ARAPAHO II/III SECOND OPINION

**LEE ENGINEERING**

October 12, 2000

Re: Arapaho Road Alignment/Access Study Review

ALTERNATE 5 OVERPASS WITHOUT RAMPS

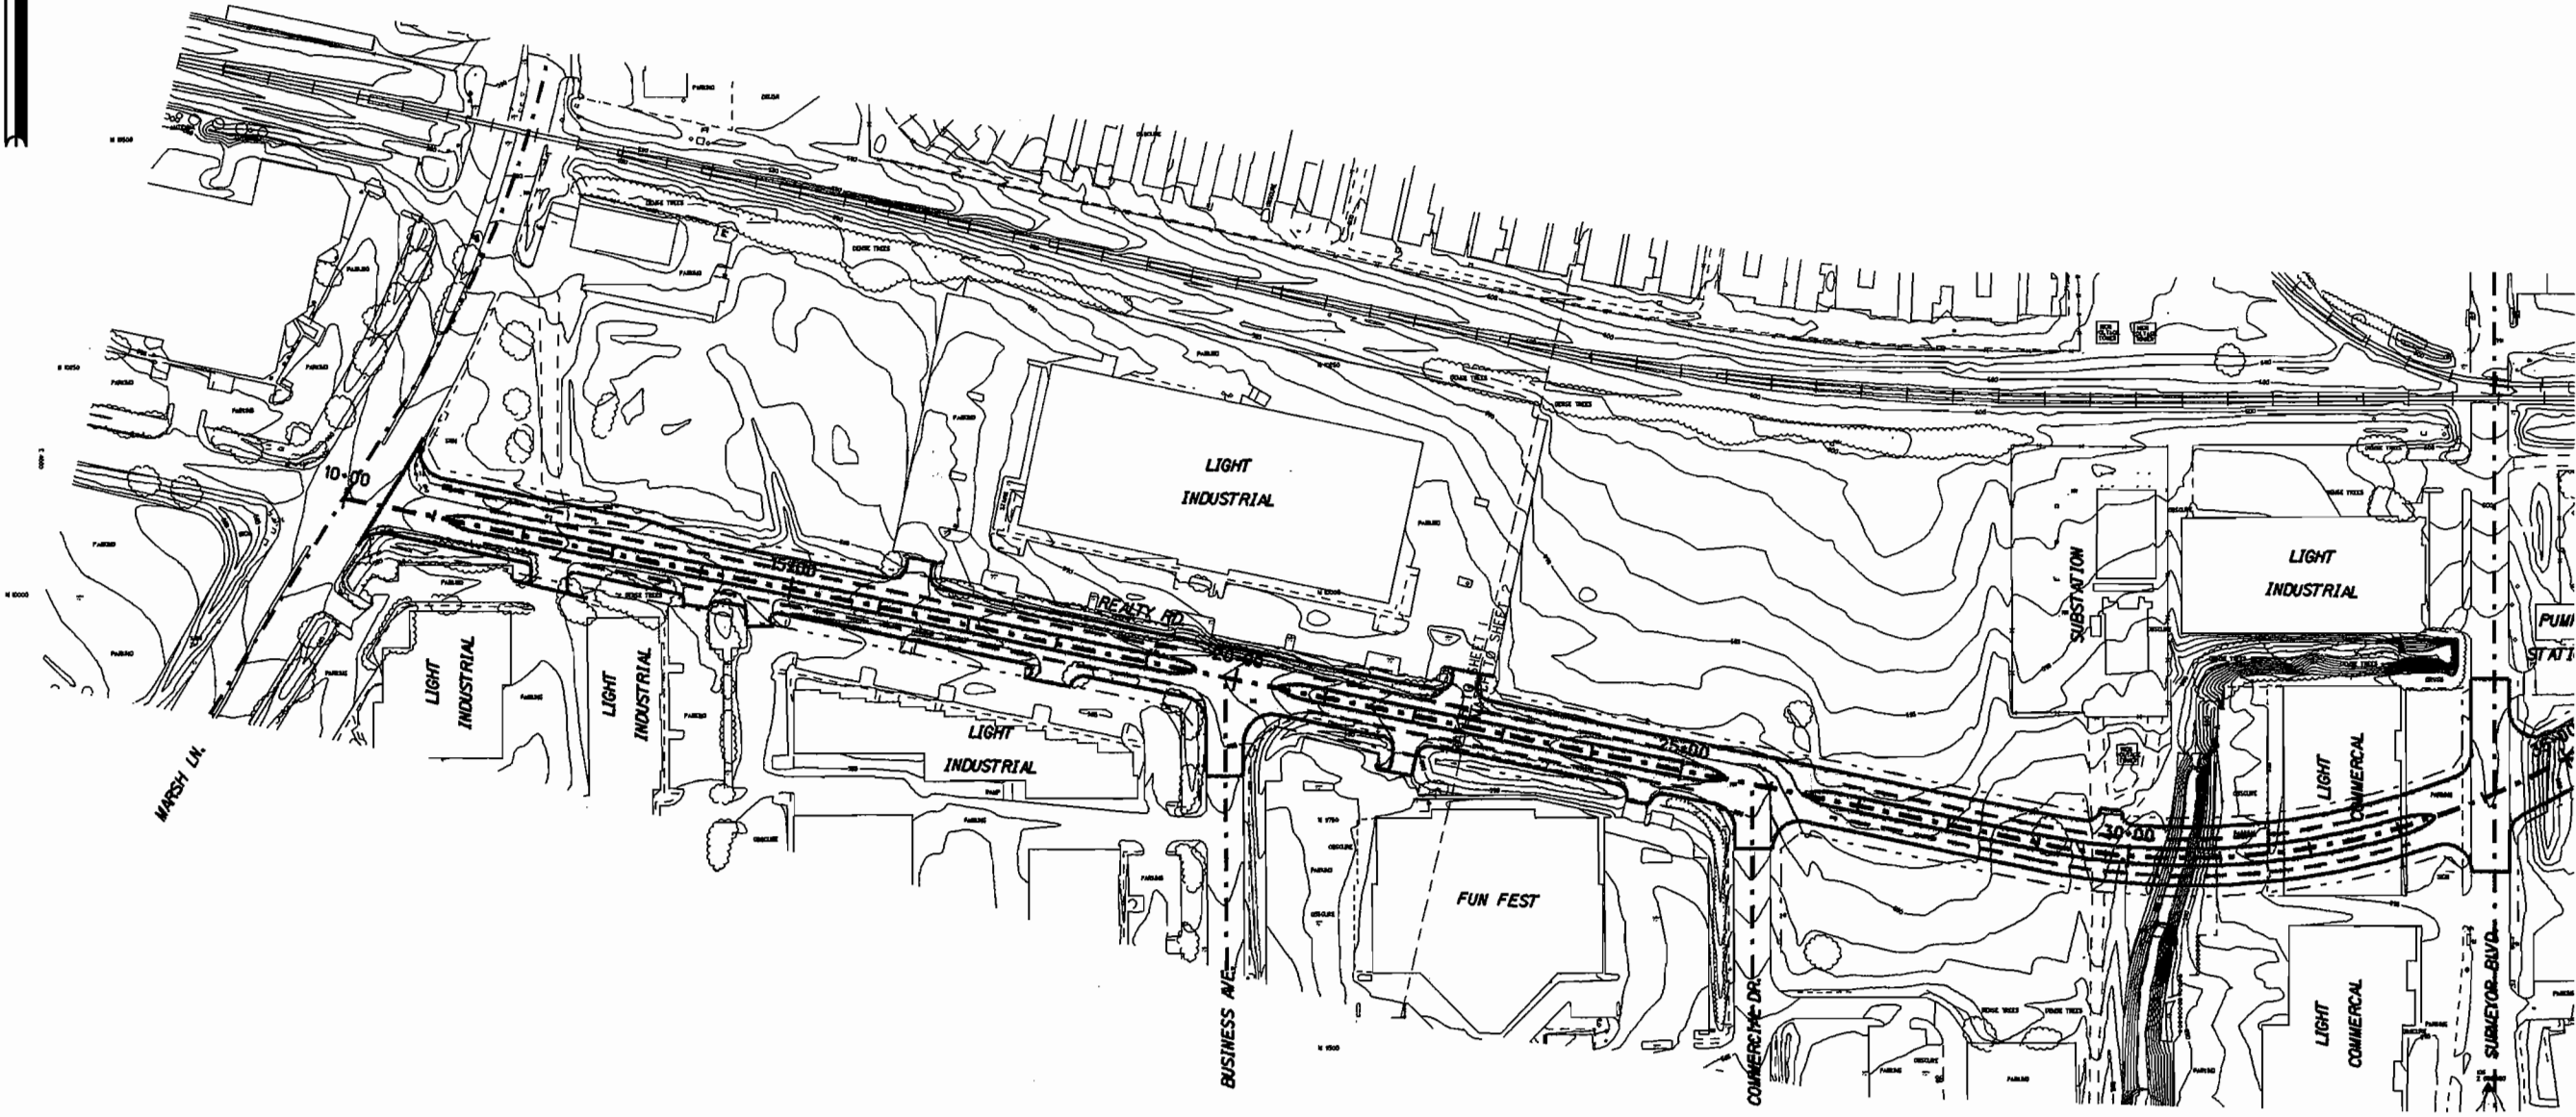
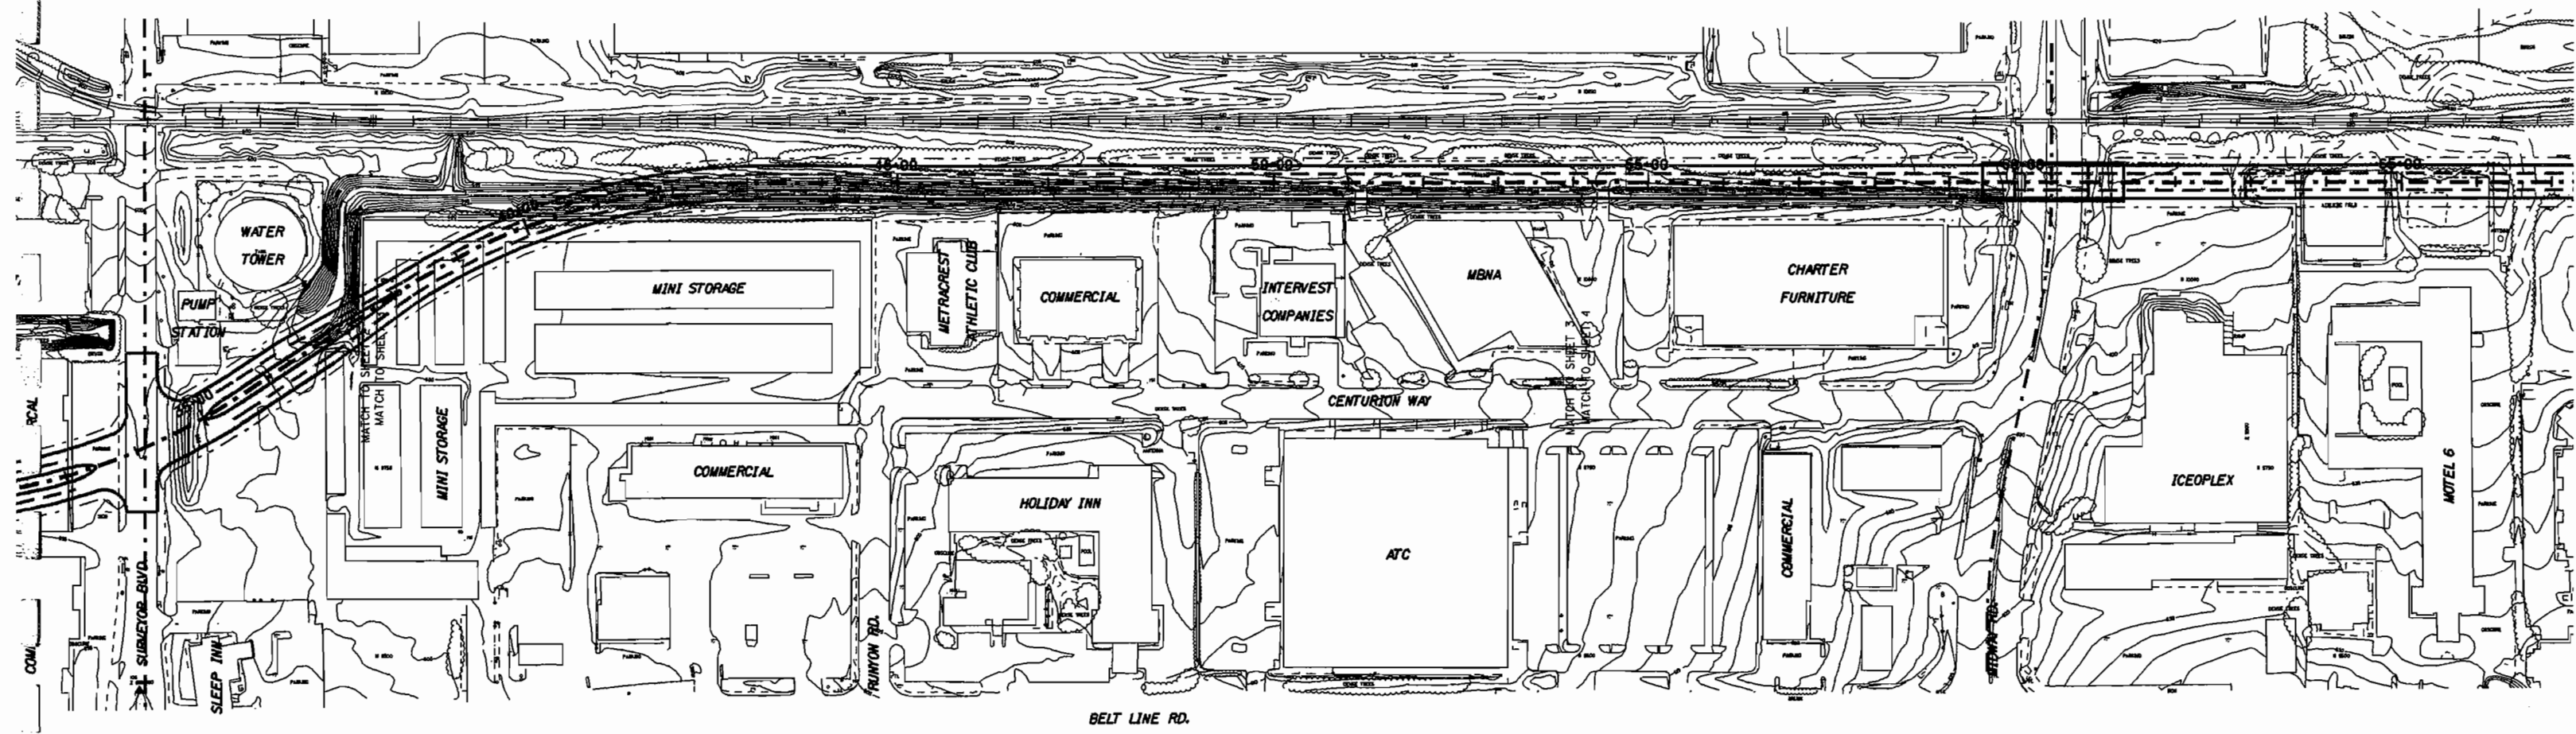
Per your request, Lee Engineering has performed a review of the Alignment Study Report for Proposed Arapaho Road Extension prepared by HNTB. The recommended configuration of Arapaho Road from the HNTB report includes an overpass over Midway Road with no connection provided for traffic to interchange between Arapaho Road and Midway Road. The primary purpose of this review was to identify connection alternatives and determine if a connection between Arapaho Road and Midway Road would be practical and would allow the Arapaho extension to be more fully utilized.

Based on our review, a connection would increase the utilization of the Arapaho extension. The connection would also impact local properties and could negatively impact traffic operations along Midway Road in the area.

The ramps required to complete the connections between the Arapaho Extension and Midway Road will have a significant impact on adjacent properties. Based on our preliminary review, these ramps would require the taking of the Charter Furniture building in the southwest quadrant of the intersection. The ramps would also take more parking area from the property on the southeast corner and eliminate the potential for providing parking for the property under the overpass structure. Preliminary schematic plans for these ramps have been prepared by HNTB.

Phase III, the extension of Arapaho Road from Addison Road to Surveyor Boulevard, includes a section that is designed to "fly over" Midway Road by way of a grade-separated overpass with no on/off ramps or signalized intersection. Because of the location and lack of access to Midway Road from the proposed overpass, Town of Addison staff was instructed to contract an outside engineering firm to perform an independent traffic engineering study of the impact and usage that would result by modifying the original design to include on/off ramps and a signalized intersection at Midway and Arapaho.

Therefore, after reviewing the traffic engineering study prepared by Lee Engineering and increased costs, including the impact to the affected properties, it is staff's recommendation to stay with the original HNTB plan of a bridge over Midway Road with *no* connection to Midway Road.
